WELWYN HATFIELD ACCESS GROUP
 THE COMMON ROOM
 GROUND FLOOR
 LEY HOUSE
 LONG LEY
 WELWYN GARDEN CITY
 HERTFORDSHIRE AL7 2EX

re: Planning Applications Received by Welwyn Hatfield Council

Application No.	Description and Location	Applicant/Agent
6/2016/0318/MAJ	Erection of additional floor to provide 1719 sq metres of B1a (Office) floor space in association with the use of the premises for B1 offices together with elevational alterations to the remainder of the building. Media House Sopers Road Cuffley Potters Bar EN6 4RY	Mr P Koscienc 21 First Avenue Acton London W3 7JP

WELWYN HATFIELD ACCESS GROUP'S RESPONSE TO PLANNING APPLICATION 6/2016/0318/MAJ

Drg.No: AT420-08

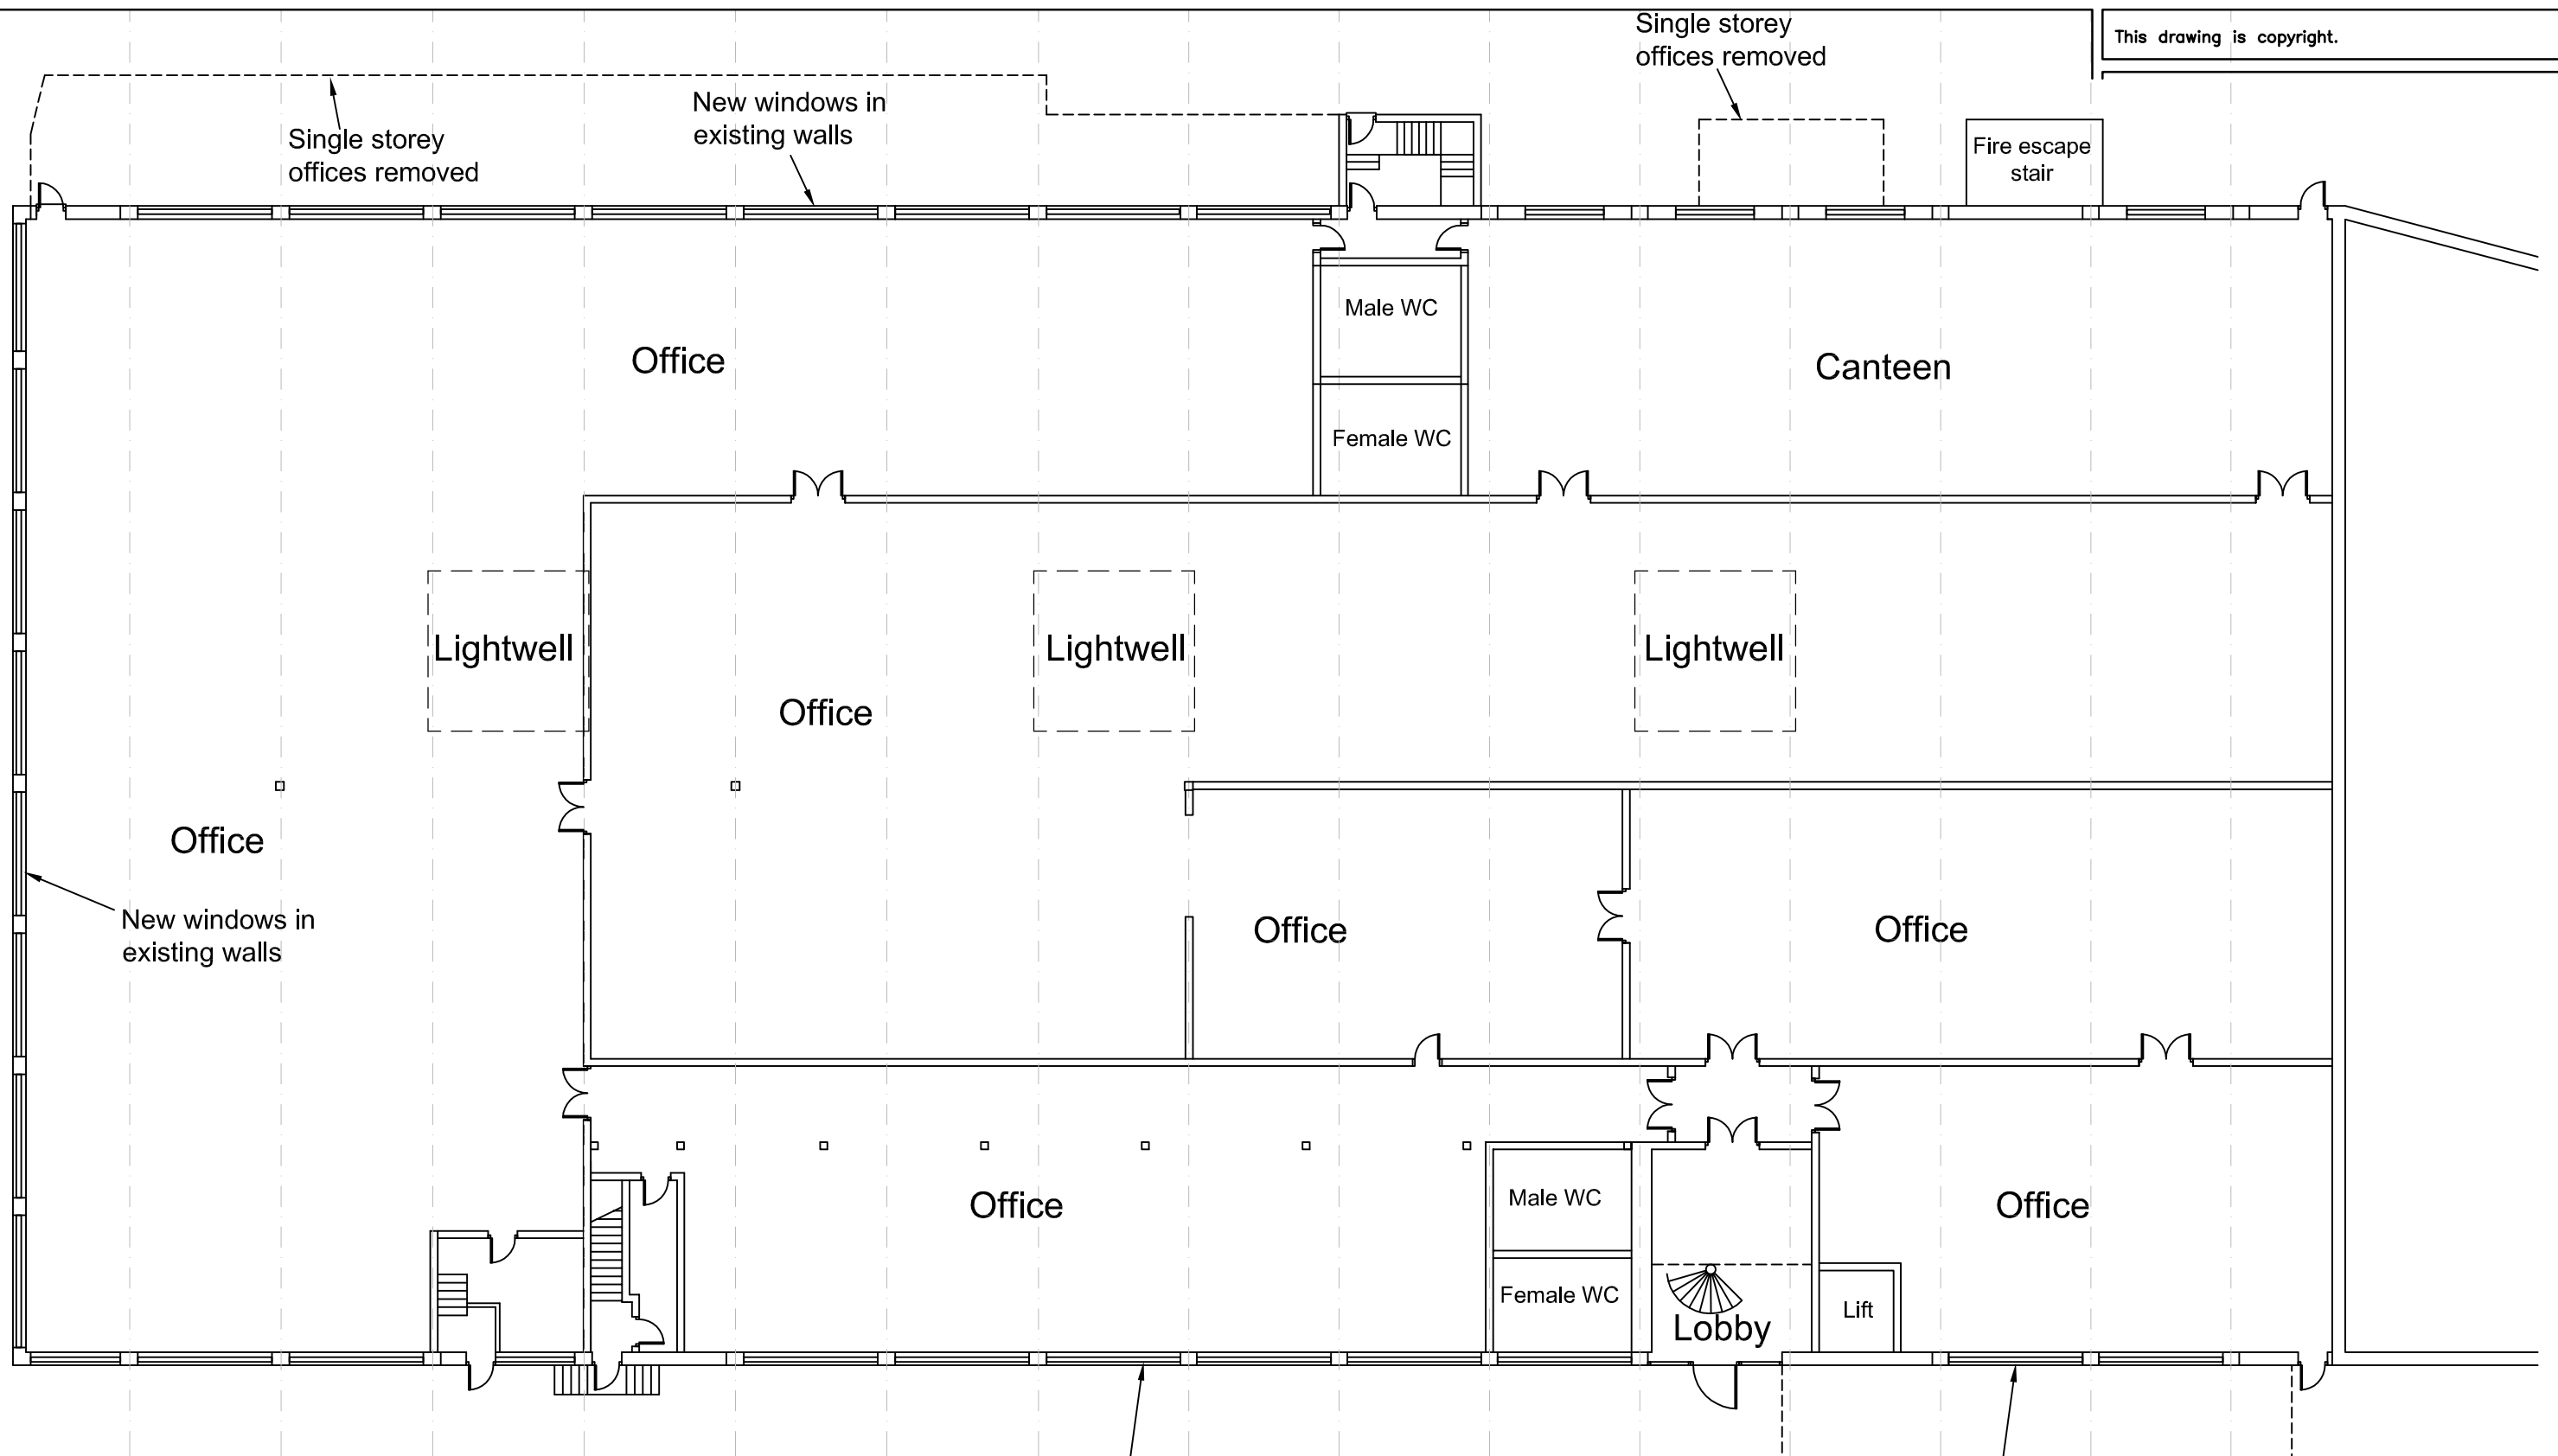
DRAWING NO. AT420-08: PROPOSED GROUND FLOOR PLAN			We note the provision of two separate blocks of toilets; each providing facilities for both male and female.	<ol style="list-style-type: none"> 2. Do the existing toilet blocks provide facilities for wheelchair users either male or female? If not, do you propose providing a (one) unisex wheelchair accessible toilet on the ground floor that will be compliant with Part M of the Building Regulations? 3. We note the provision of a lift (presumably accessed from the lobby) on the ground floor. Is this a passenger lift and does it serve as an evacuation lift in the event of emergency egress? Please also provide details of the lift's internal dimensions and confirm it meets best practice guidelines.

Drg.No: AT420-09

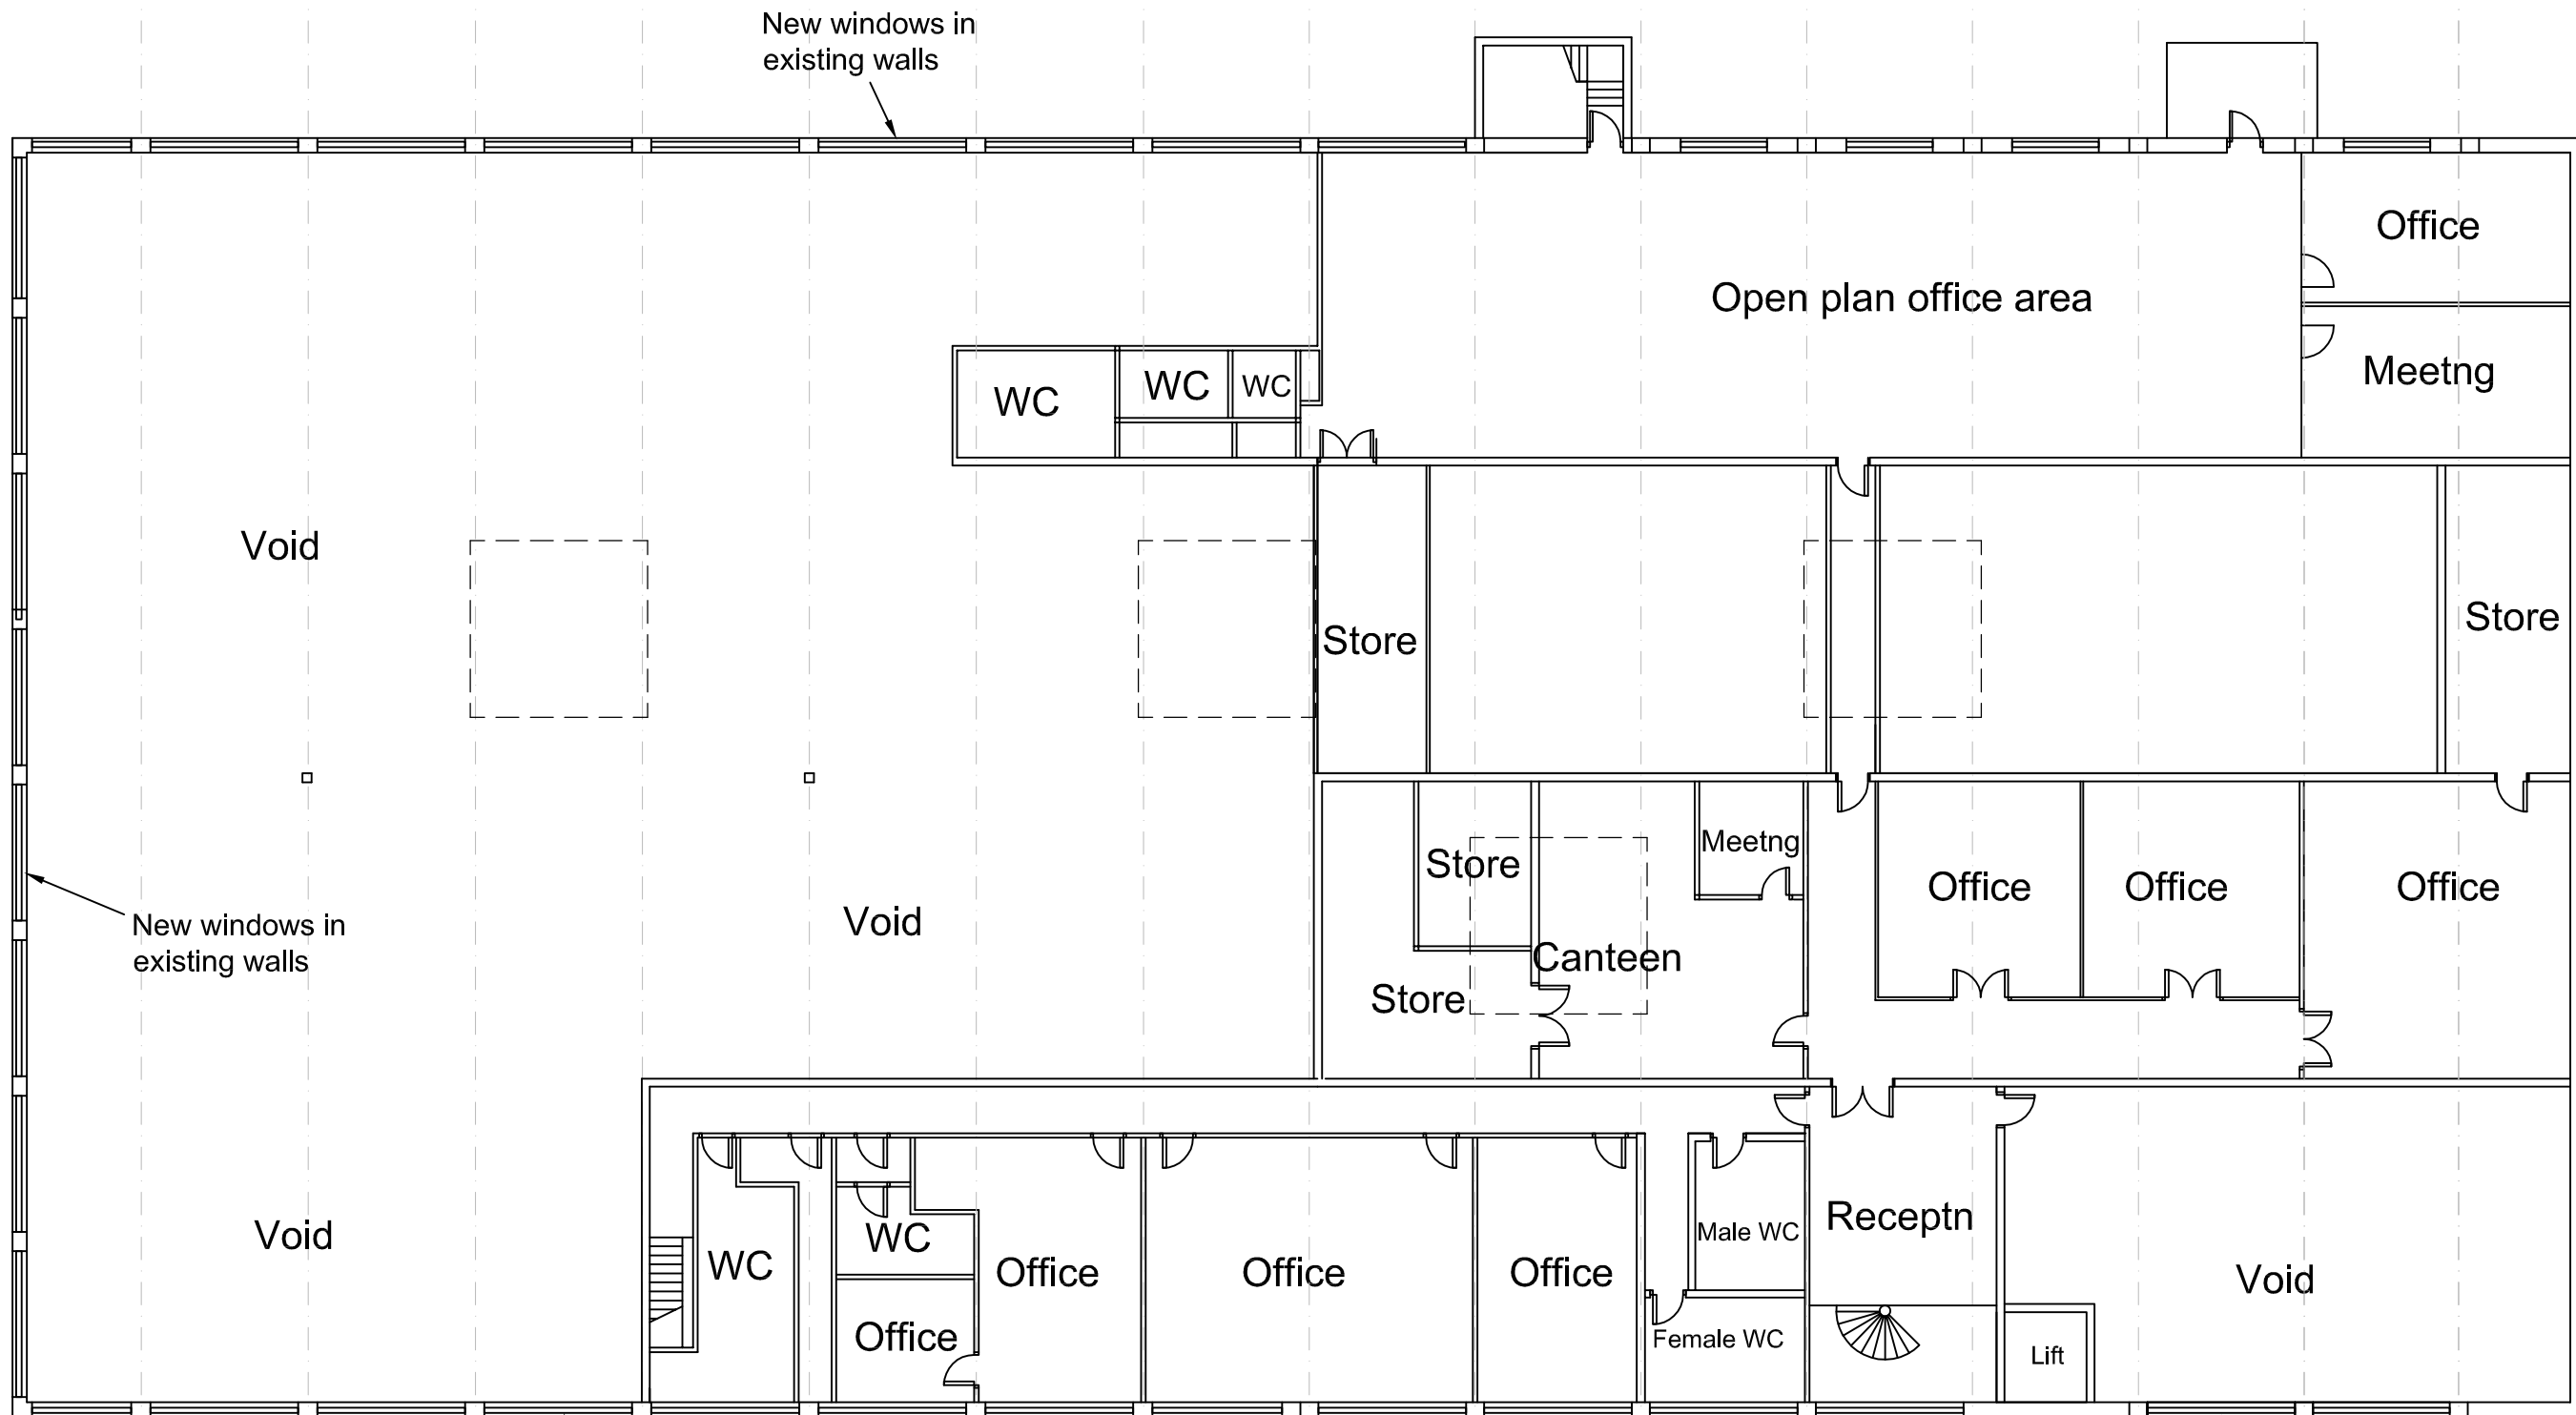
DRAWING NO. AT420-09: PROPOSED FIRST FLOOR PLAN			We note the provision of seven separate toilets on this floor of which two are designated male and female.	<ol style="list-style-type: none"> 4. Are any of these toilets wheelchair accessible?

Drg.No: AT420-10

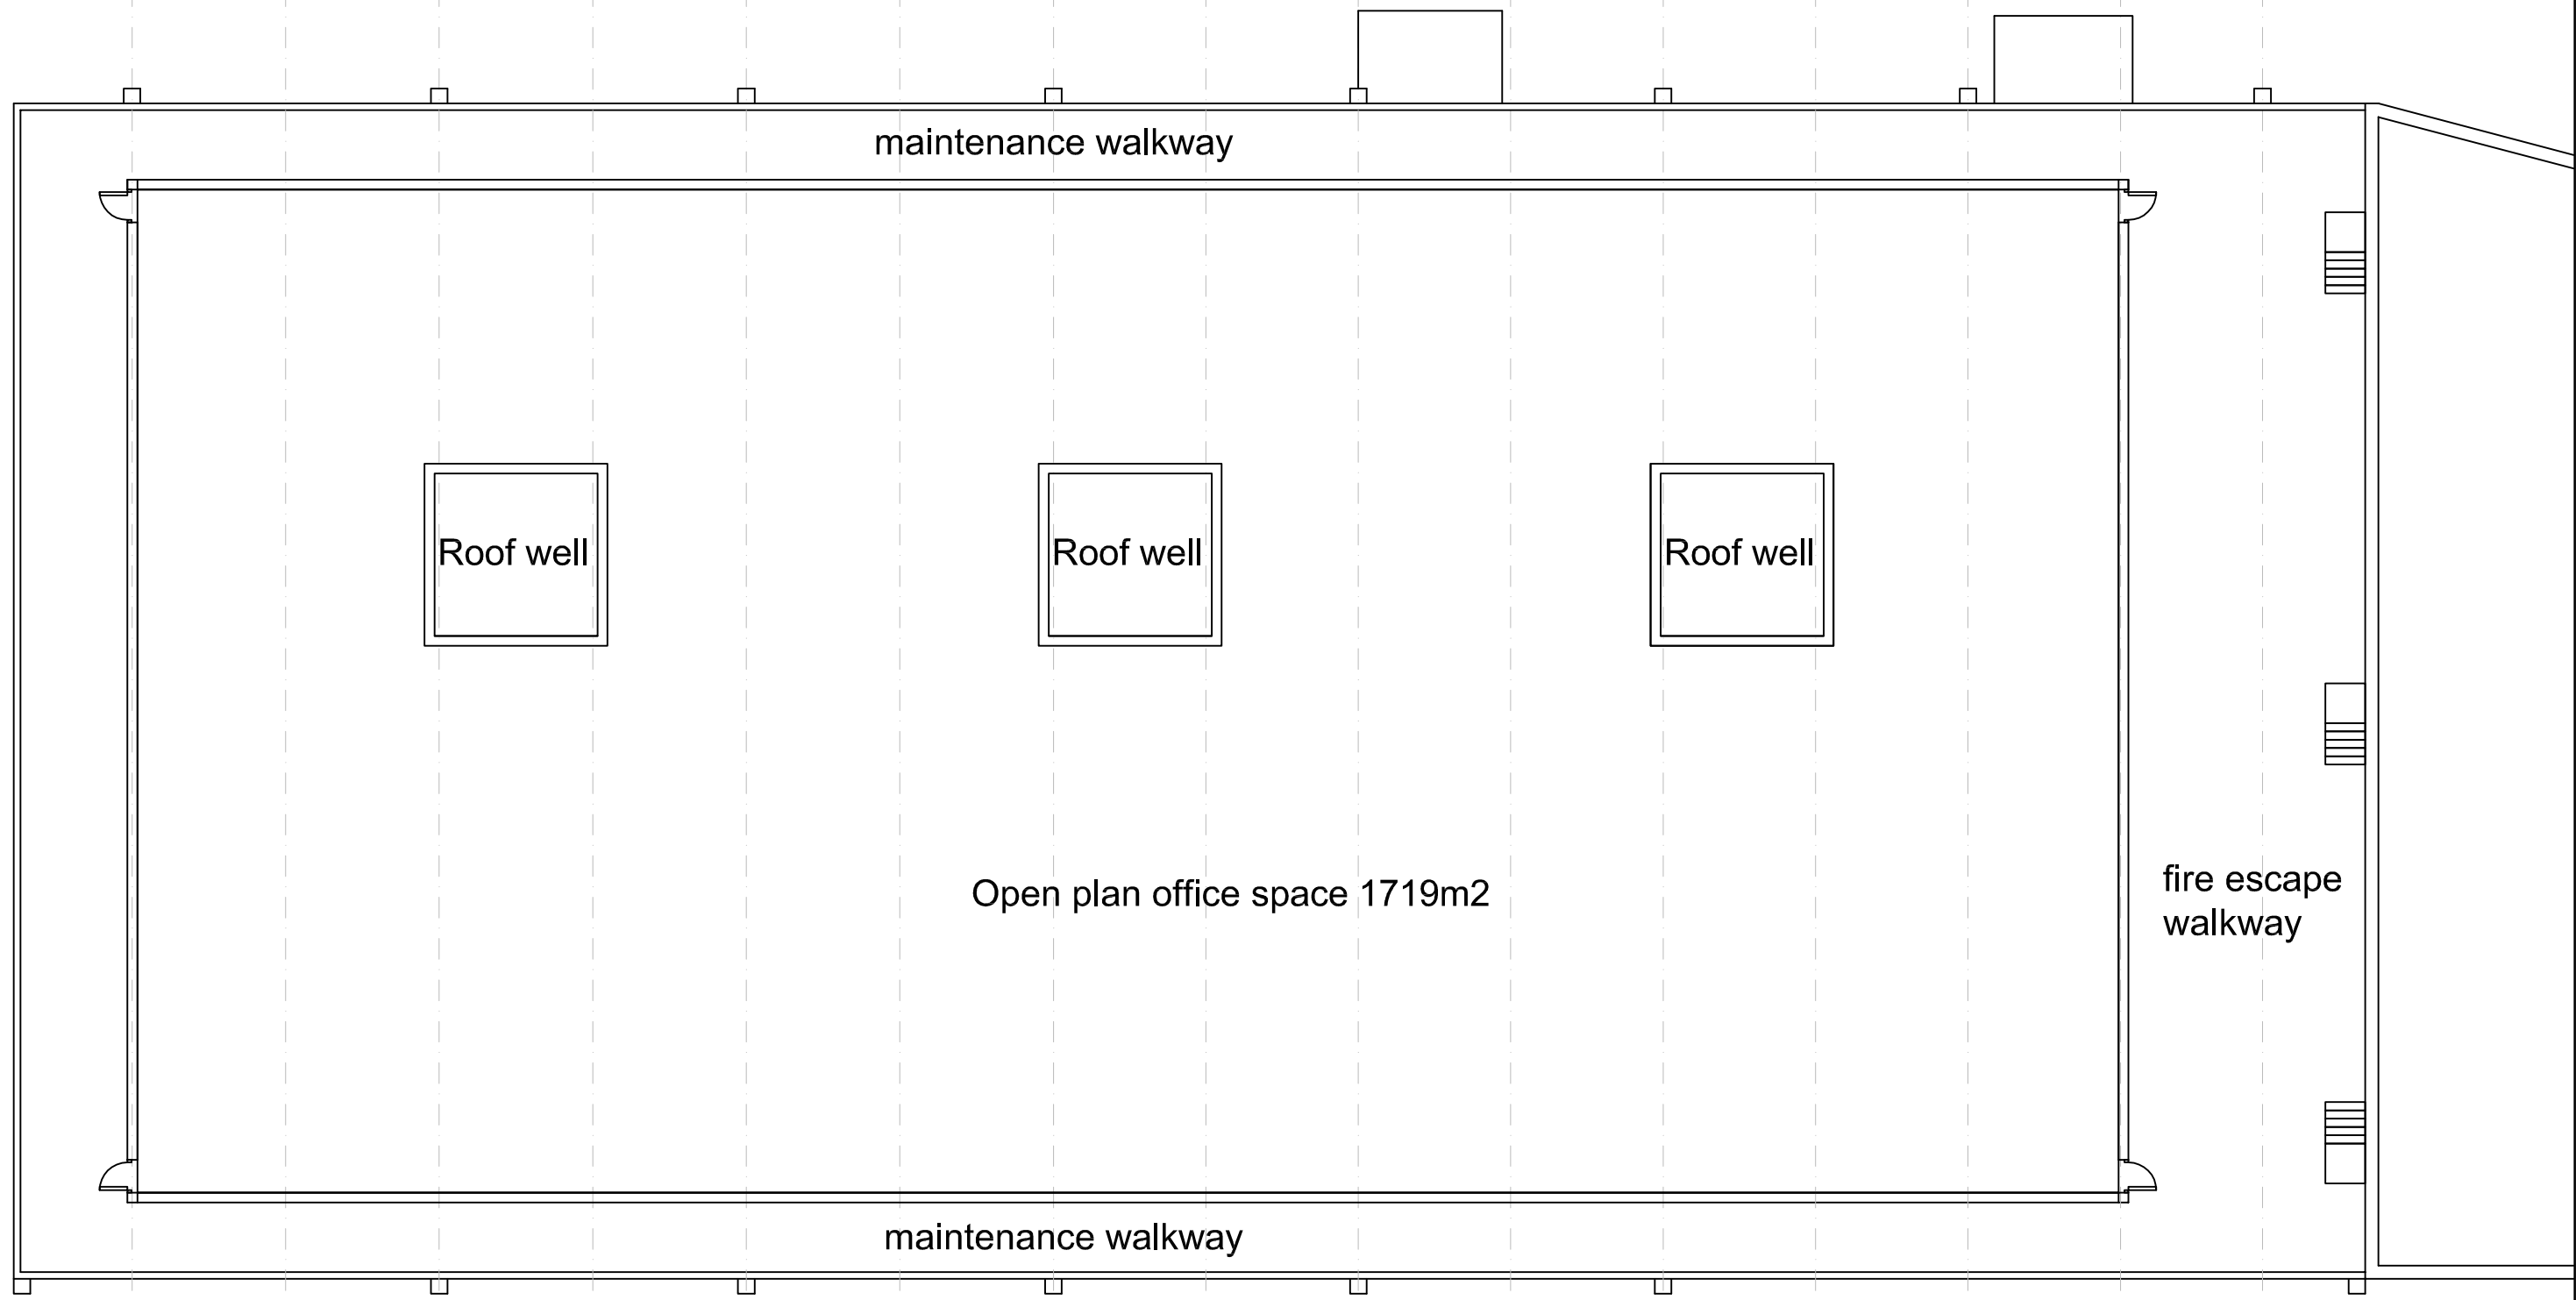
DRAWING NO. AT420-10: PROPOSED SECOND FLOOR PLAN			This drawing relates to the proposed new floor space and does not include any detailed layout proposals.	<ol style="list-style-type: none"> 5. Do you propose to extend the lift shaft to this floor? 6. If you are providing toilet facilities on this floor, will there be any provision for a wheelchair accessible unit? If so, it should be Part M compliant.
EMERGENCY EGRESS			<p>We note reference to 'Fire Escape Stair' on the Ground Floor drawing and we believe this core extends up to the First Floor.</p> <p>The proposed Second Floor Plan shows a Fire Escape Walkway.</p>	<ol style="list-style-type: none"> 7. Are any refuge points planned for the upper floors and, if so, could you please provide details of where these will be located?
